Reference No:	<b>2025/62/93129/W</b>
Site Address:	395, Manchester Road, Marsden, Huddersfield, HD7 6DP
Description:	Raising of roof height, demolition of existing rear lean-to extension and erection of two storey rear extension with associated alterations
Recommending Officer:	Joshua Merriman

**DECISION – Conditional Full Permission**

## **Officer Report – 2025/93129**

Scale: 1:50 & 1:100	Drawing Number 2025/016/03	Rev. C	Date Drawn March 2025	Drawn By Andrew Smith
------------------------	-------------------------------	-----------	--------------------------	--------------------------

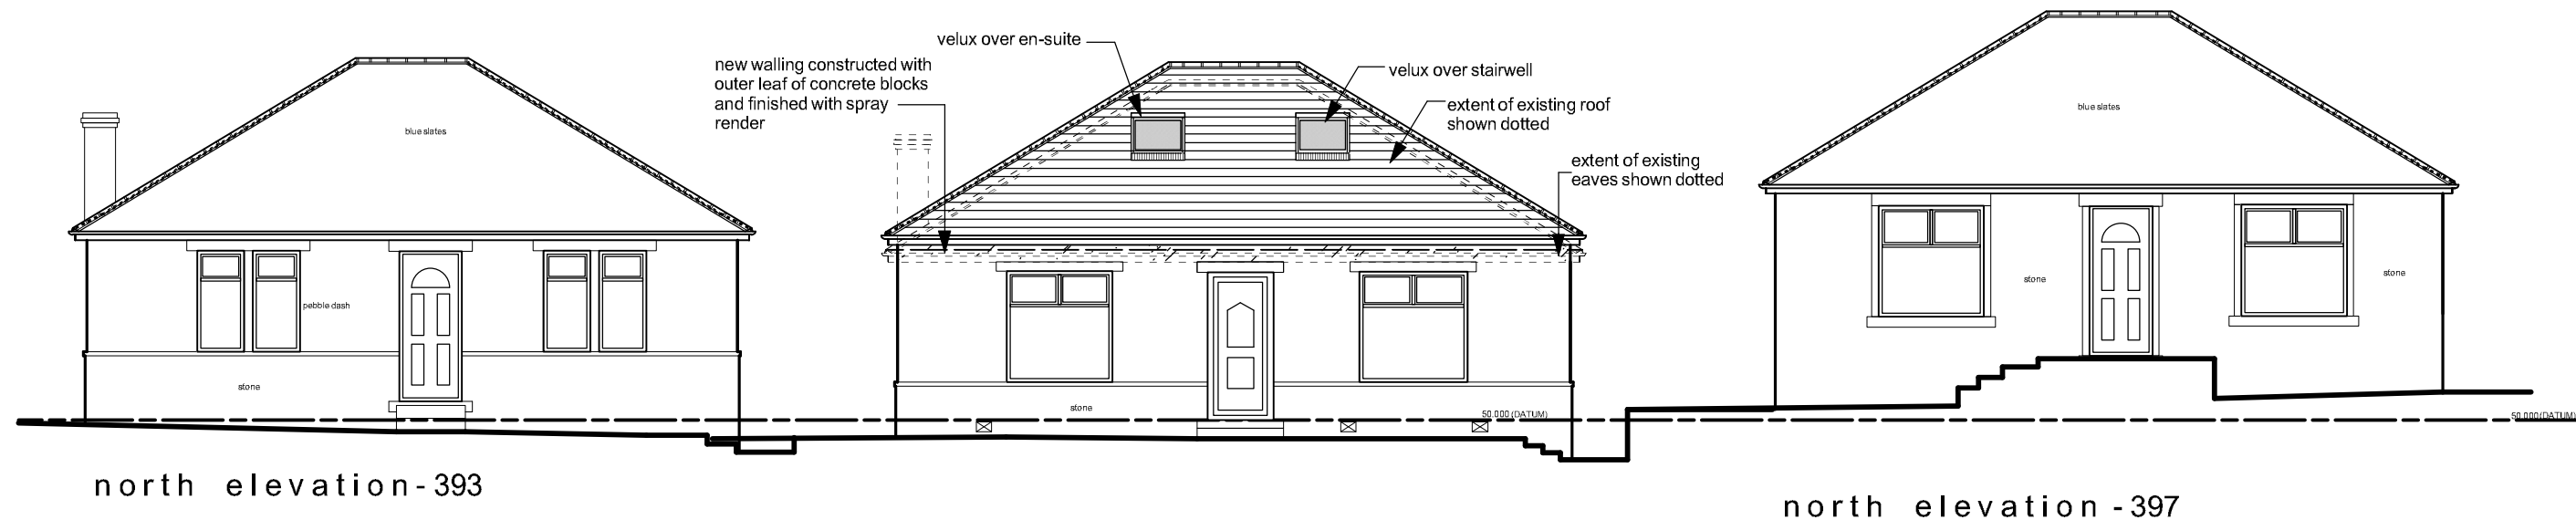
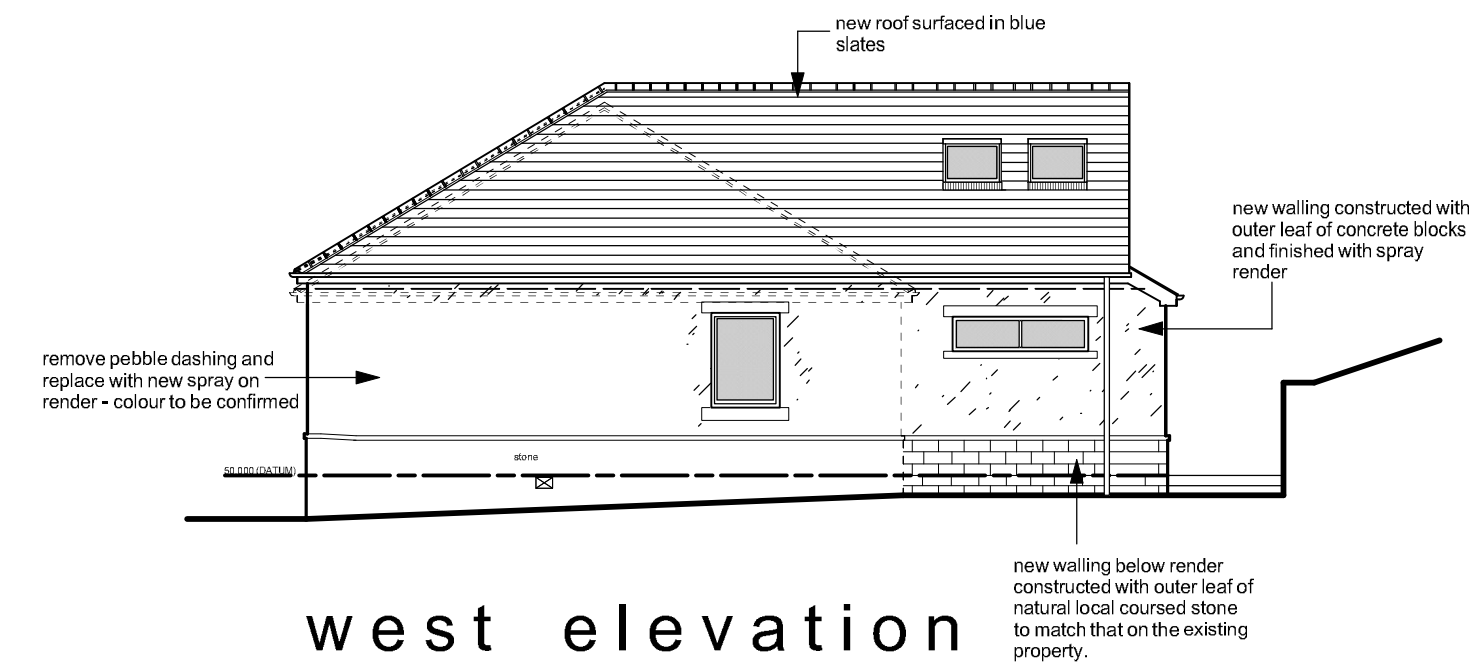
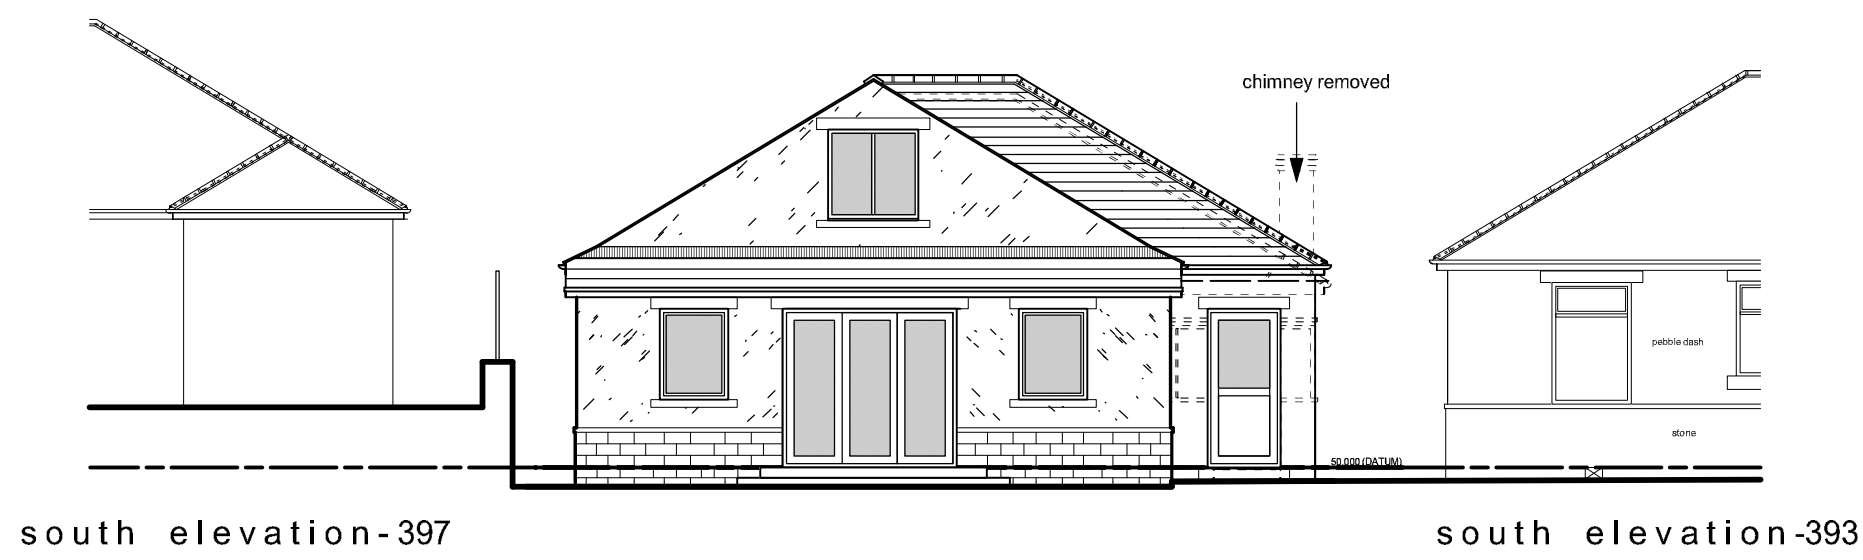
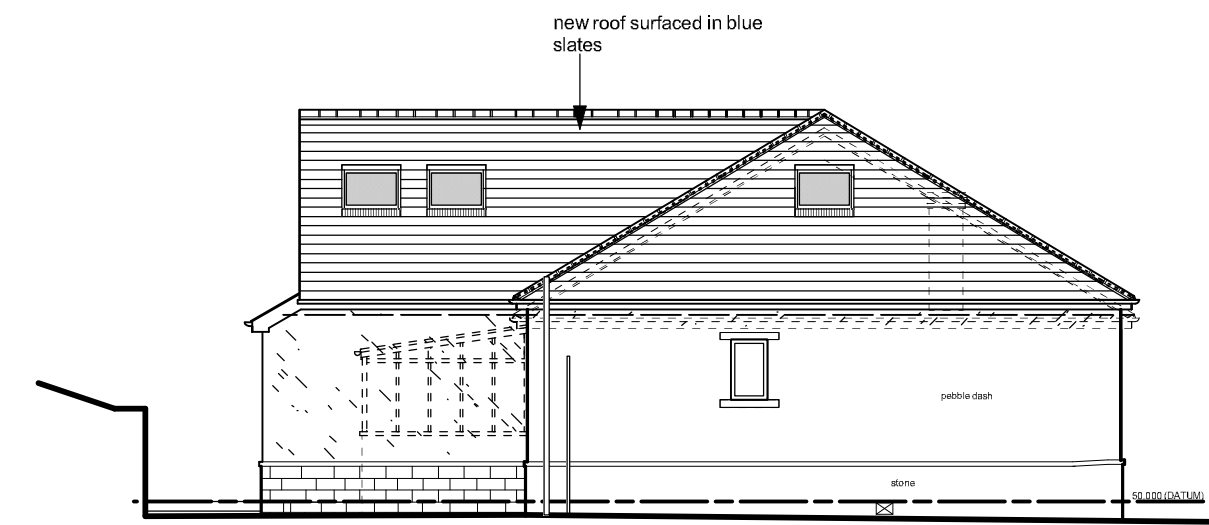
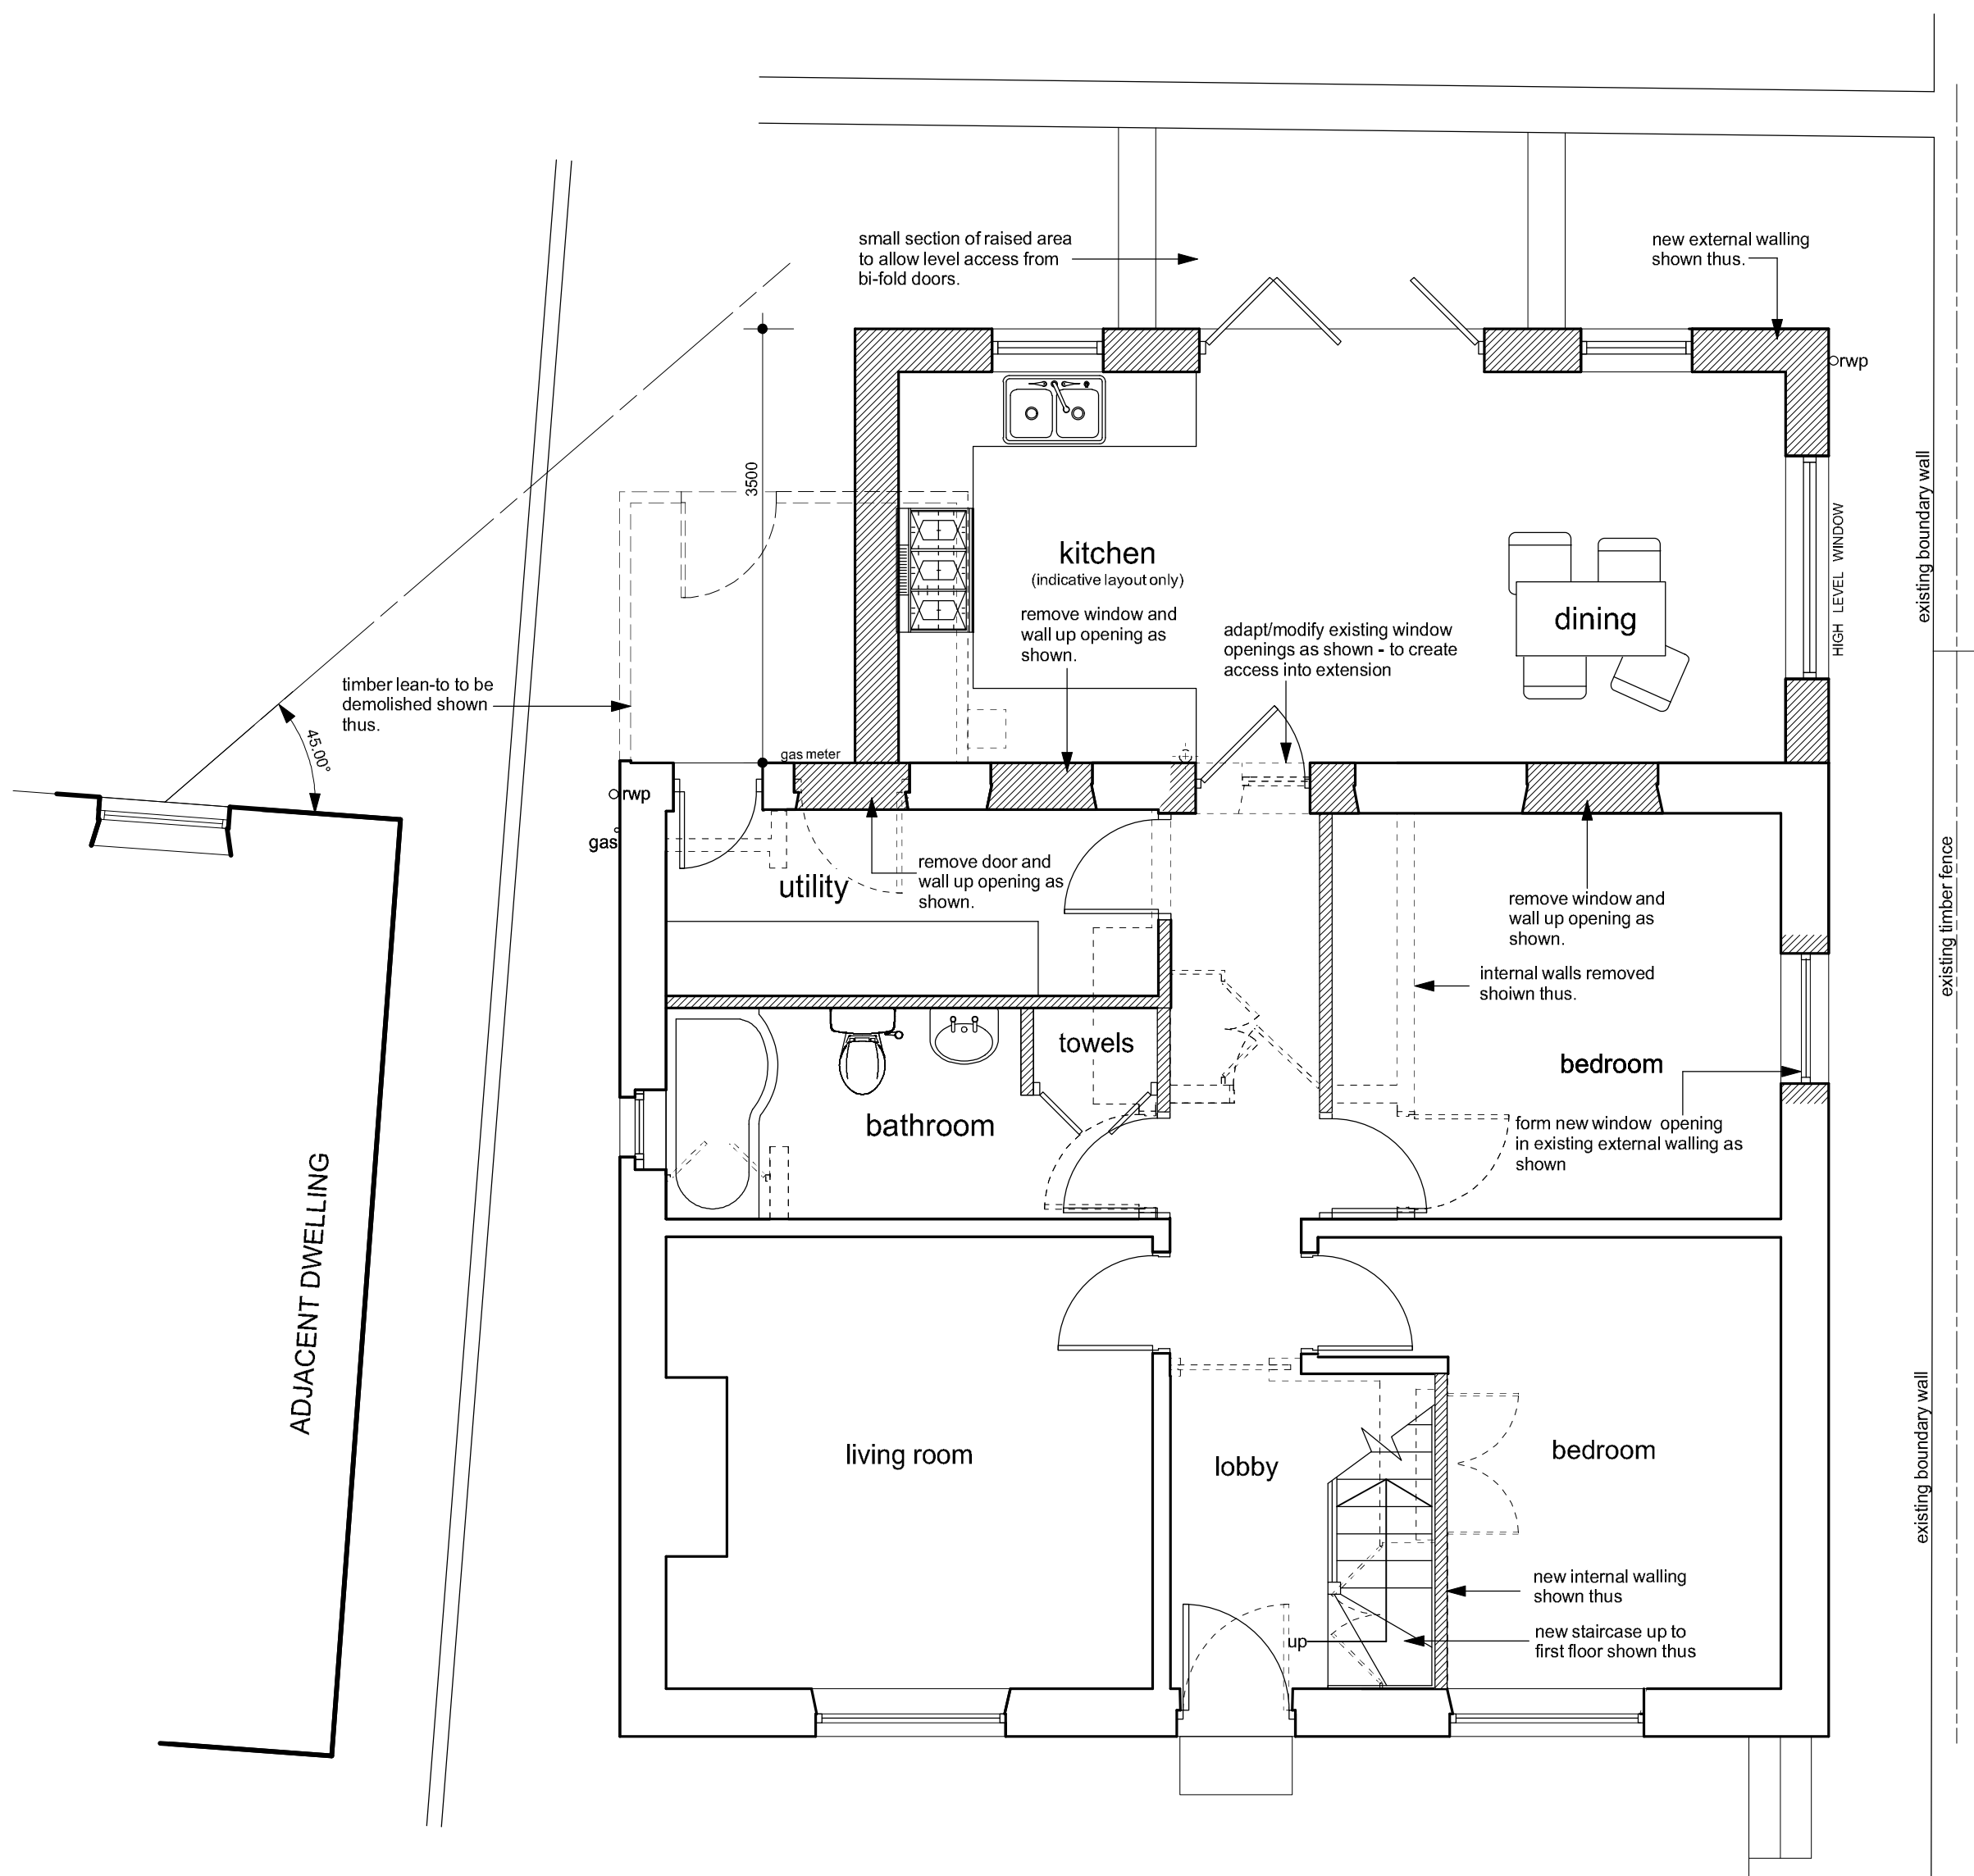
The case officer sought it necessary to reduce the overall scale of the development as the application site is located within the Green Belt. Upon communicating this to the agent, amended plans were submitted showing a reduction in the increase in eaves height and total height of the rear extension by 350mm, and a reduction in the projection of the rear extension from 3.5m to 3m.

The extension is set in approx. 3.5m from no. 393 and it meets the 45 degree code as shown on the submitted floor plan. Given the generous separation distance in place, the proposed rear extension is not considered to result in adverse overbearing or overshadowing impact that would warrant a refusal and is therefore acceptable.
